ISPT submits this objection as the owner of 100 Pacific Highway, North Sydney, regarding the Development Application (SSD-83956216) for 105-153 Miller Street, North Sydney. The site, known as the MLC Building, is State Heritage Listed and consists of the Denison Street Wing and the Miller Street Wing.

The SSDA proposes adaptive reuse of the existing commercial building including alterations and additions for the purpose of accommodating a tertiary institution (university). The DA was publicly exhibited on 8 July 2025 – 6 August 2026. There is a separate DA (DA387/24) that was lodged in December 2024 for a commercial office scheme, which is currently being assessed by North Sydney Council.

105 MILLER ST SECTION

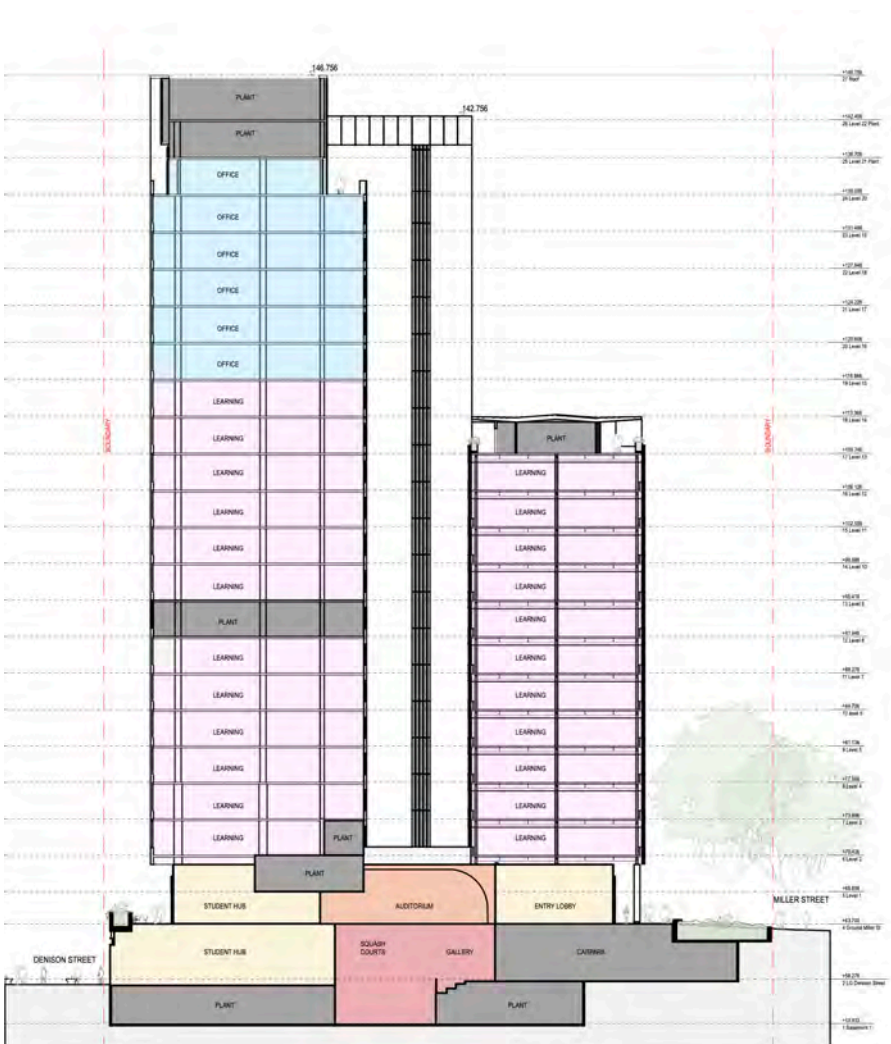
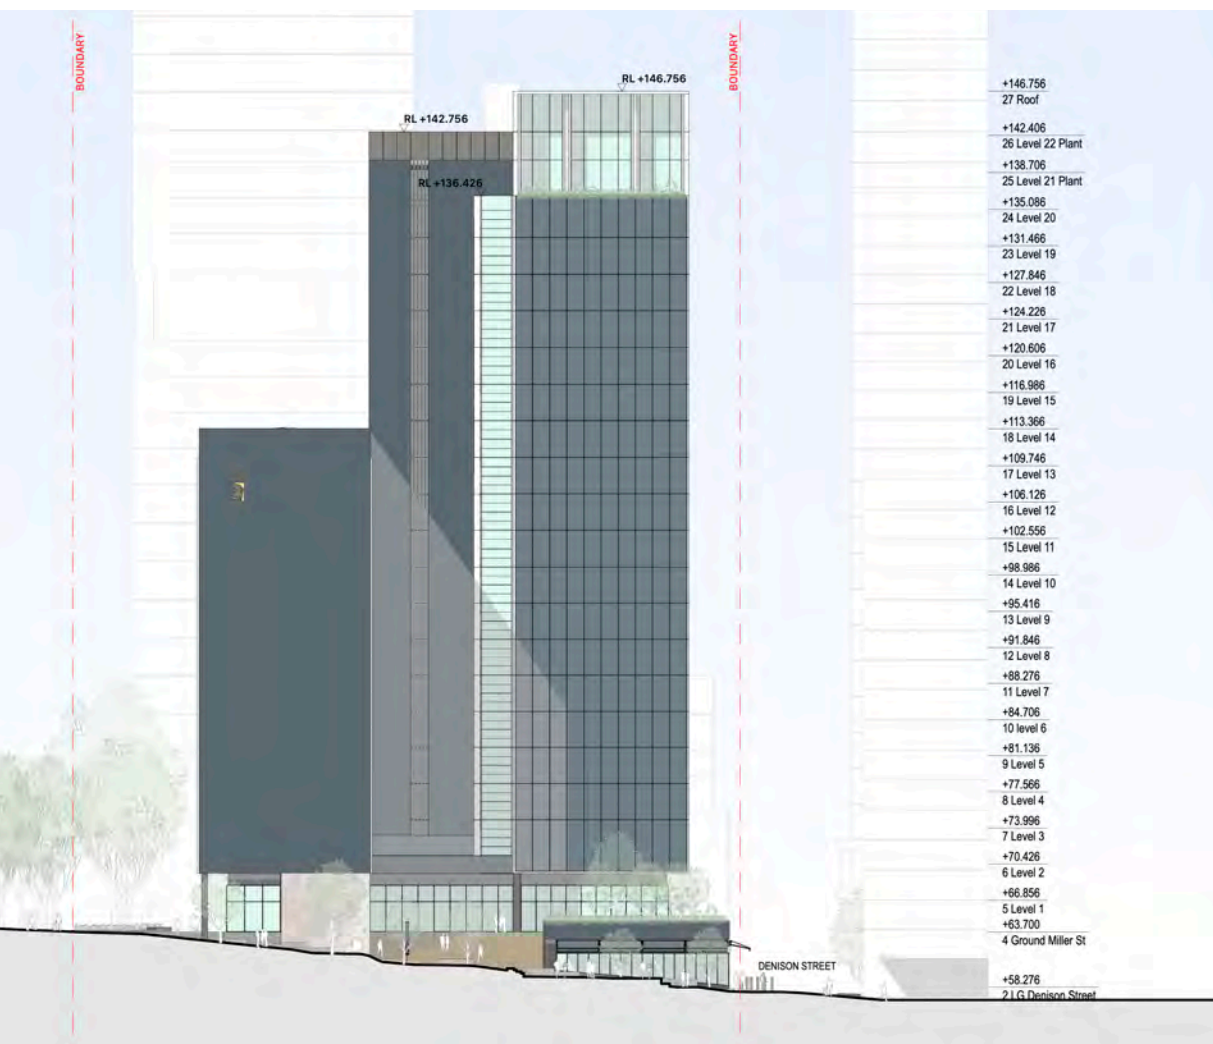
The proposed development has a maximum building height of RL151m, which exceeds the maximum building height control of RL125m prescribed for the site under the North Sydney Local Environmental Plan 2013 by 26m (a 17.2% exceedance).

The current 125m AHD height limit in the LEP allows for an additional two or three storeys above the Miller Street Wing, not the seven or eight storeys proposed.

The height of the Denison Street tower should be reduced. Considering the bulk and scale of the proposed building core and the Denison Wing in relation to the remnant Miller Wing and the site's unique urban context, both building height and setbacks need to be decreased.

It is recommended that the proposed building height be reduced to comply with the height of building control (125 RL) to achieve a more appropriate balance of new development with an acceptable level of impact.

The proposed Denison Street Wing dominates the Miller Street Wing in height and scale, adversely impacting its heritage interpretation of the Miller Street Wing. The proposal does not fully comply with the Conservation Management Plan (CMP) endorsed for the building, which recommends flexibility around alterations and additions rather than full demolition. Council's heritage officer notes that if the demolition of the existing eastern wing is approved, the new addition should be reduced in scale to match or be lower than the Miller Street Wing. The hierarchy between the Miller Street Wing and Denison Street Wing should be clearly retained and interpretable, with the width of the new wing matching that of the existing western Miller Street Wing. It is important to consider the rationale behind allowing a building that is six storeys higher than the prescribed limit. In our view the proposal does not maintain an acceptable relationship with the heritage item and extent of the Denison Street Wing should be reconsidered. The height, bulk and scale impact could be ameliorated by reducing the height and bulk of the new elements to avoid an overwhelming dominance over the heritage item.
